Historic England

13th January 2021

Planning Act 2008, Scottish Power Renewables, Proposed East Anglia One North (EA1N) and Two (EA2) Offshore Windfarm

Historic England Deadline 4 Response

Figure: 8g
CHVP3: PROW between Moor Farm and Little Moor Farm

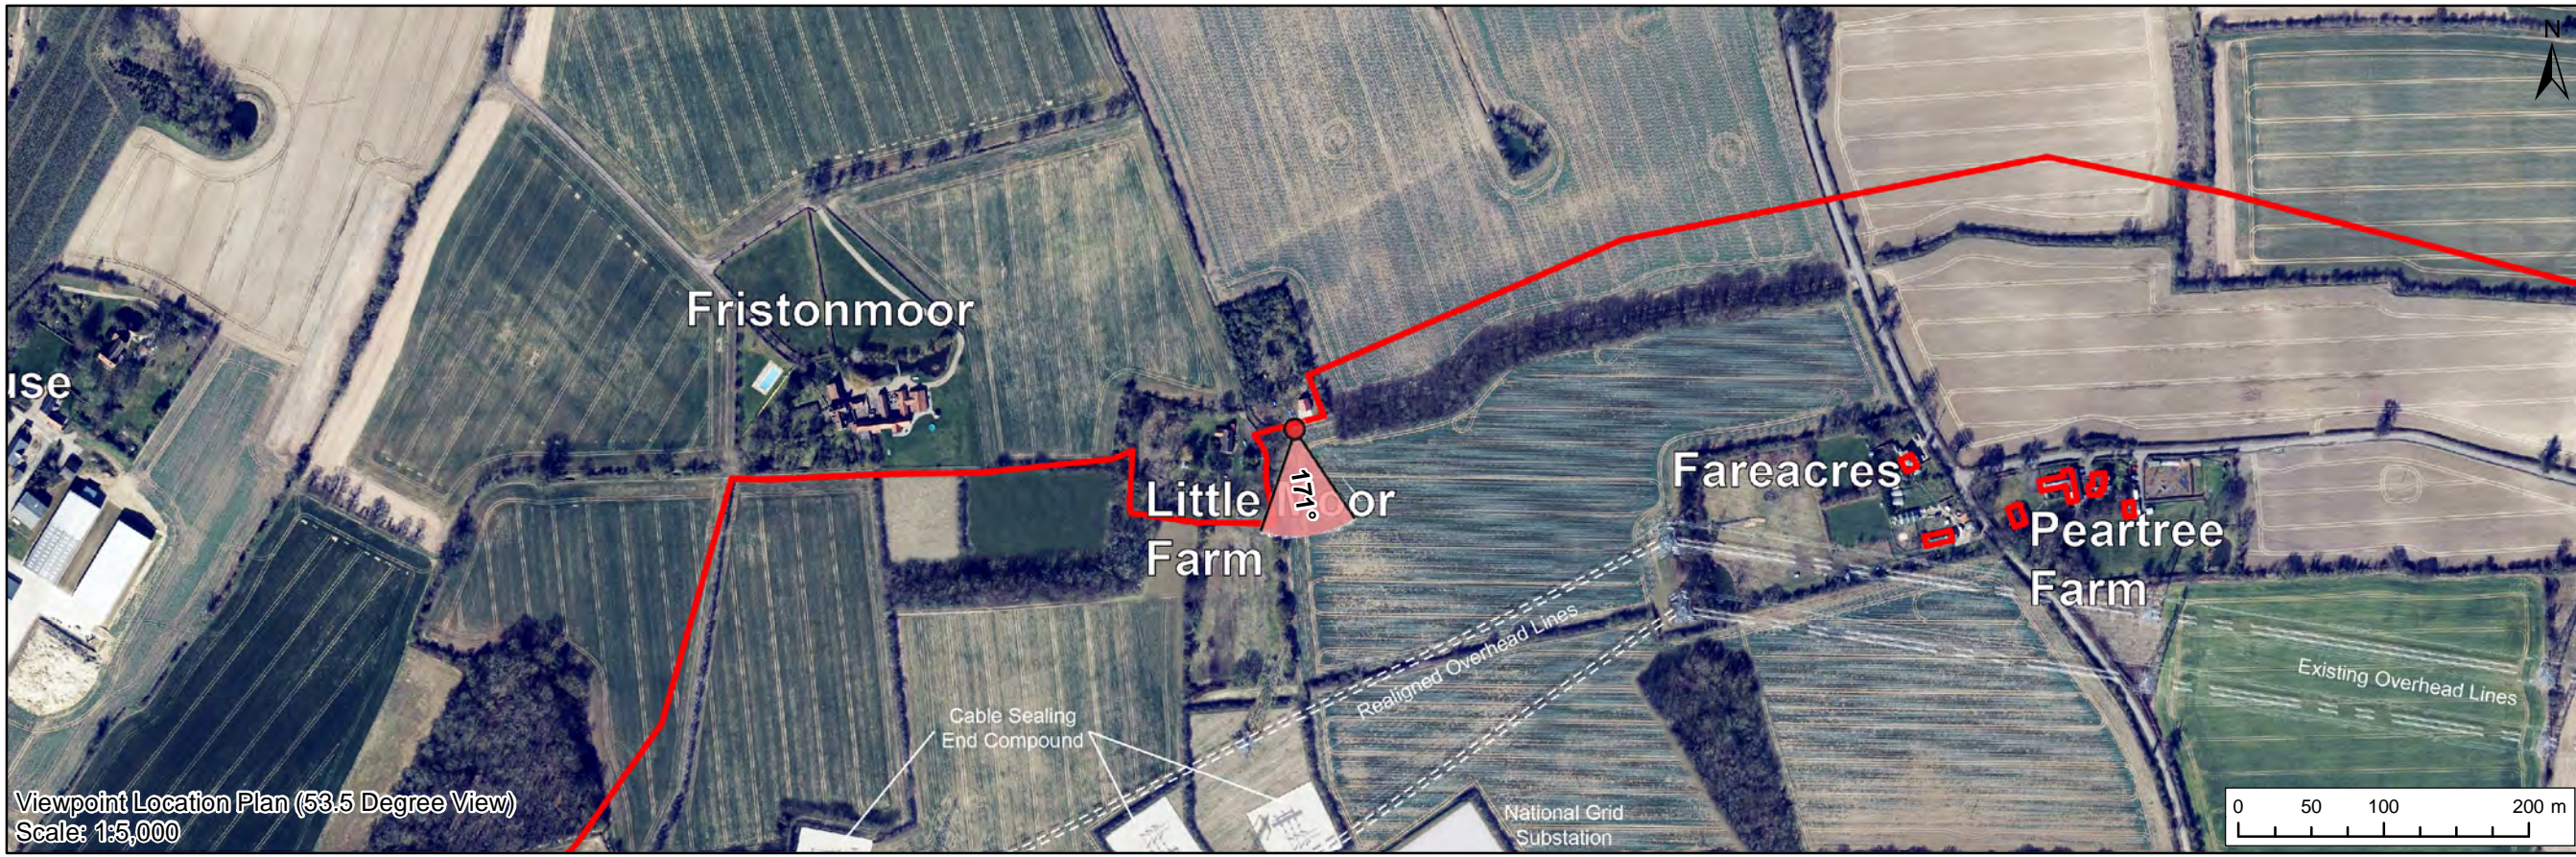
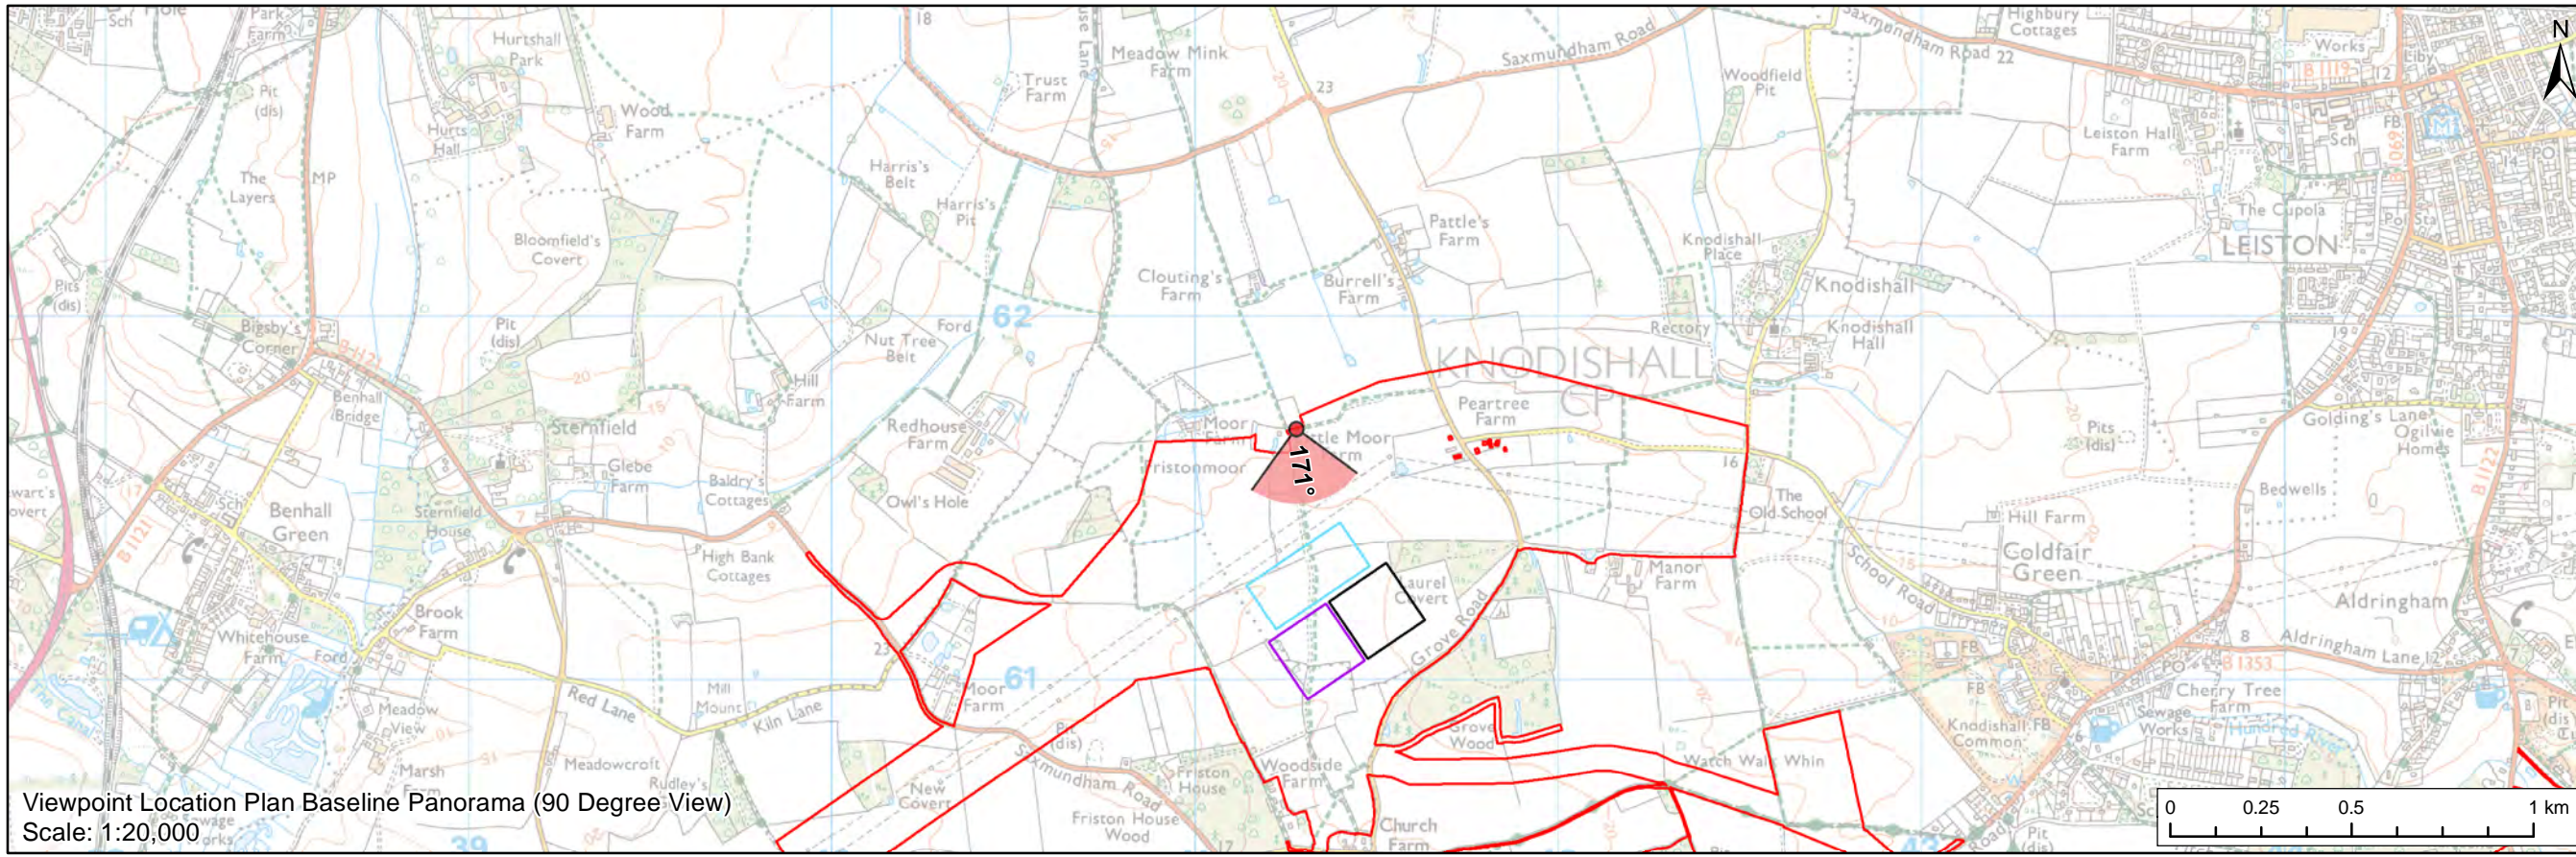
Views of the church from the north will still however be obliterated as illustrated (CHVP4), and in spite of the changes the loss of the footpath will continue to lead to a change to the relationship between the church and this land to the north. We not feel it is necessary to repeat the case we have presented with regards to the important contribution this area of land to the north of the church makes to the significance of the church, and how it is experienced in this landscape. Our position remains consistent with that presented in previous advice from 2018 onwards.
